From: Hannah Riddle on behalf of Planning.Responses
Sent: 26 April 2022 16:20
To: Planning Scanning
Subject: FW: Planning Re-Consultation on: Y/32/22/DOC

Engineers Comments Regarding Condition 8

Application No: Y/32/22/DOC
Registered: 8th March 2022
Site Address: 10 Acre Field Grevatts Lane West Yapton Bognor
Grid Reference: 498000 101780
Category: Discharge of Condi

Description of Works: Approval of details reserved by condition imposed under ref W/4000394 (Y/102/18/PL) relating to Condition Nos 8 - surface water drainage and 10 - maintenance & management of surface water drainage system.

Drainage Construction Details Proposed Basin Detail

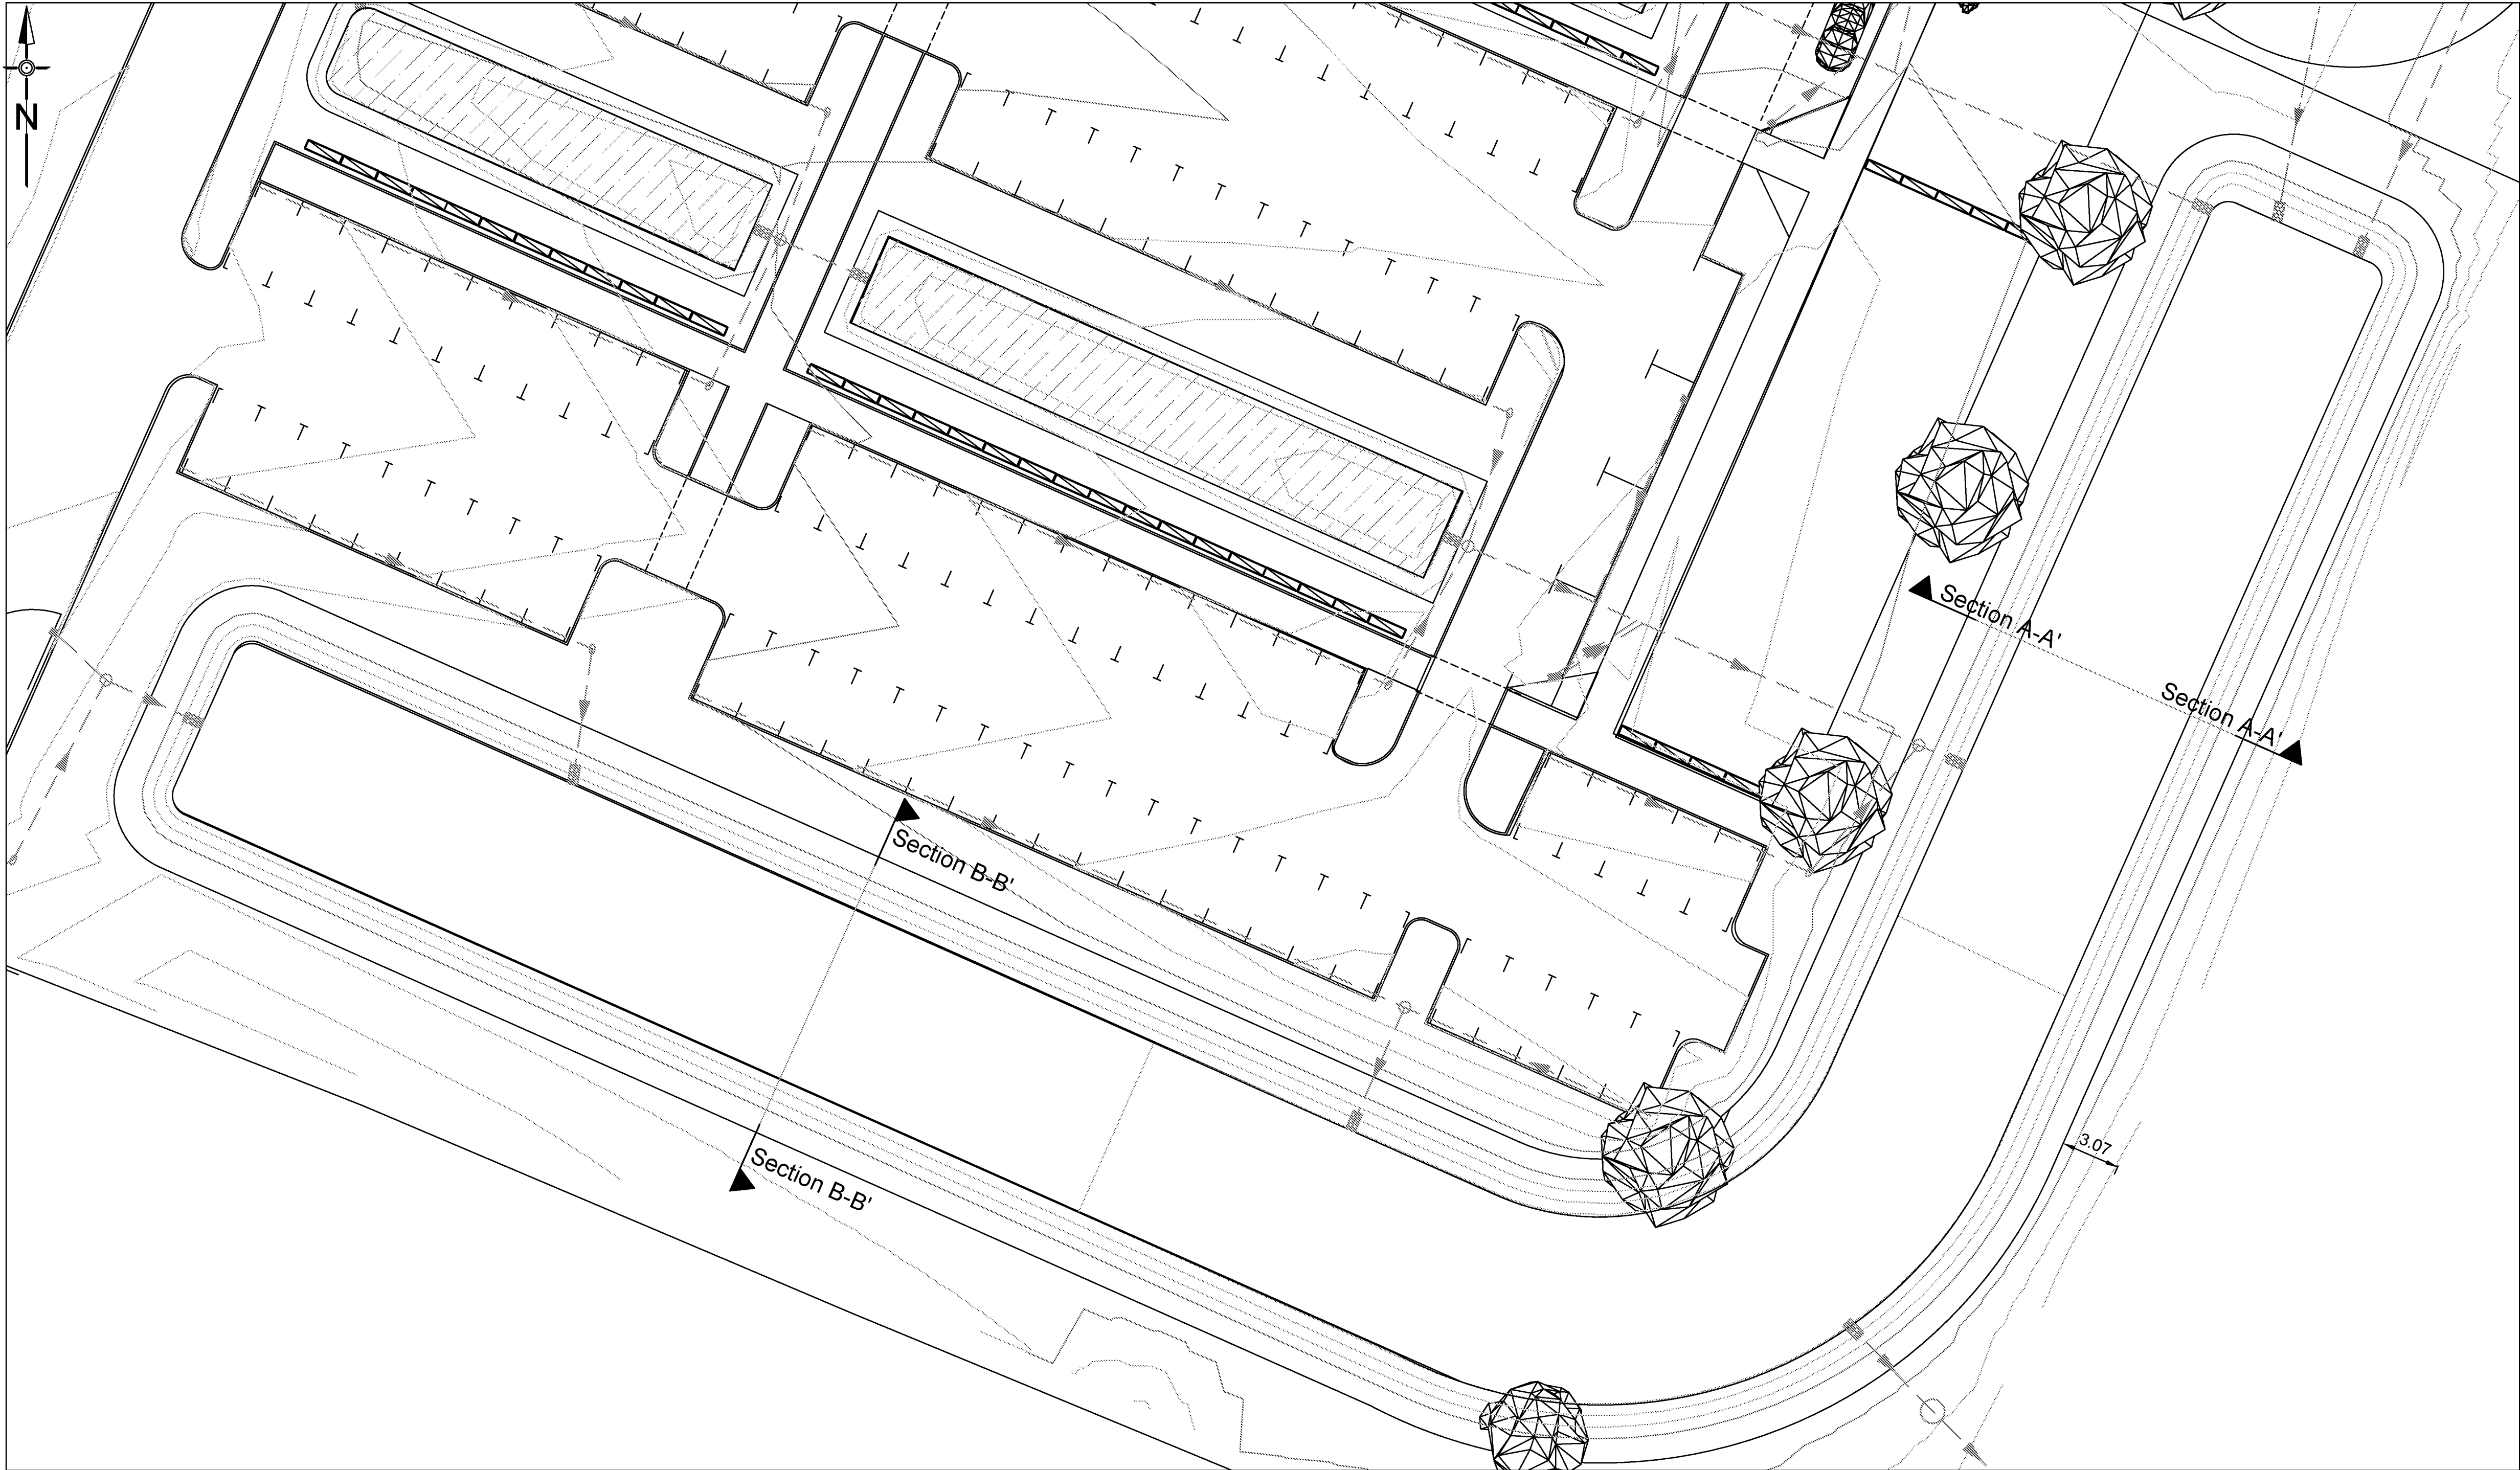
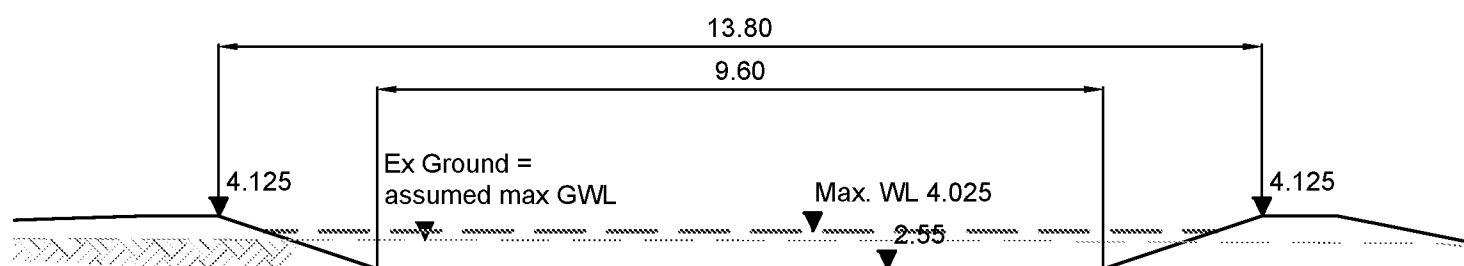
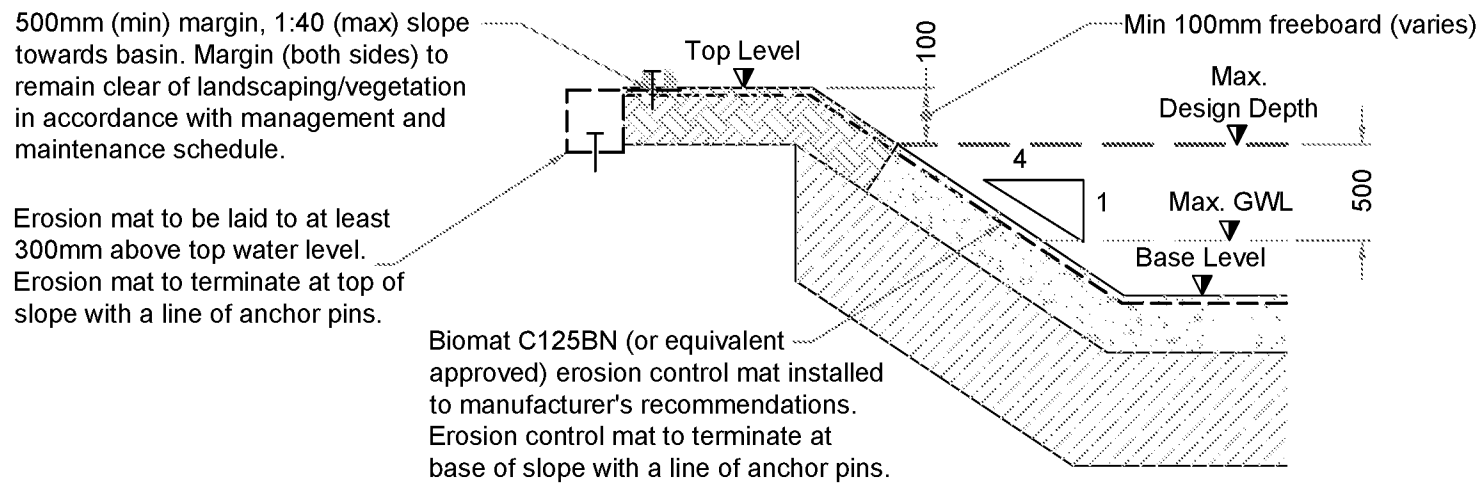
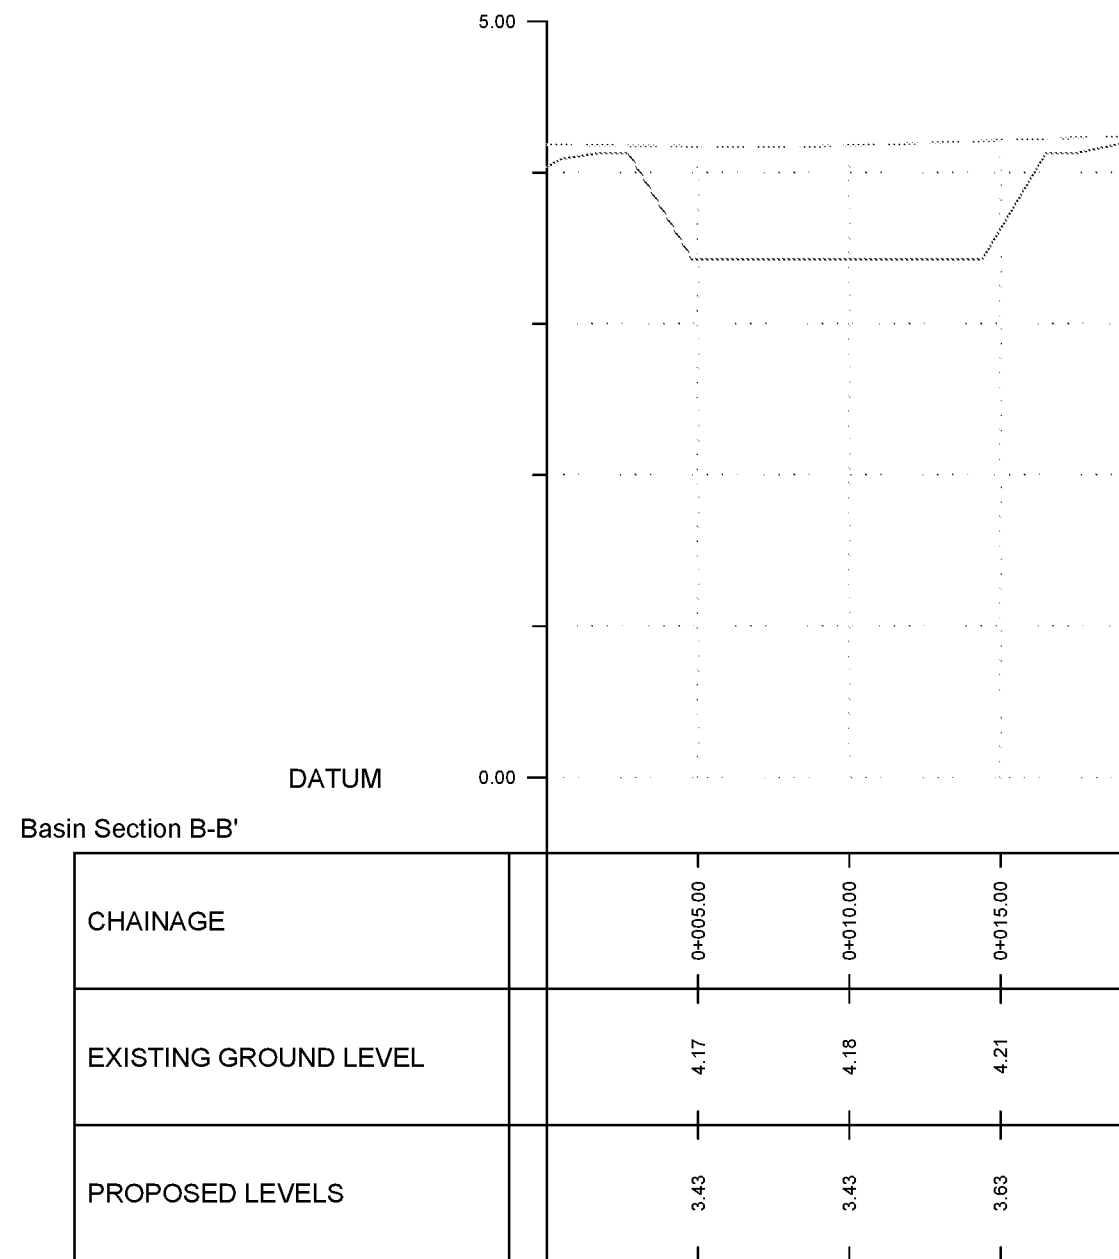
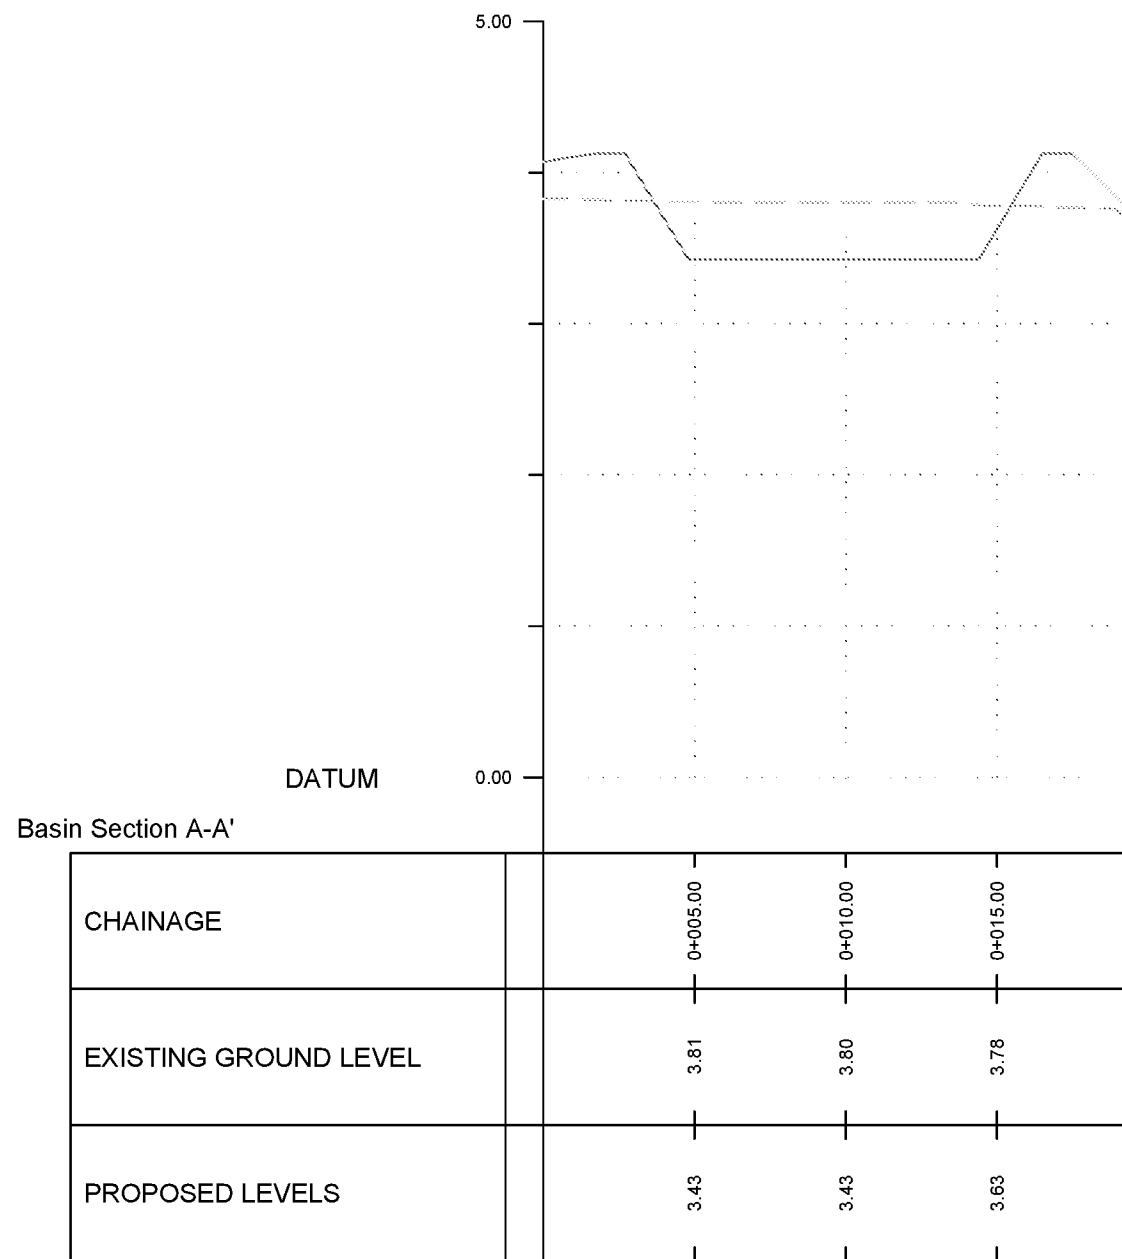
9. Please supply site specific construction details of the attenuation basin, showing invert level, top of bank level, width at bed and width at bank. Please see enclosed basin detail drawing 13591-CRH-XX-XX-DR-C-5310 Revision P1. *To be reviewed once principals are agreed.*
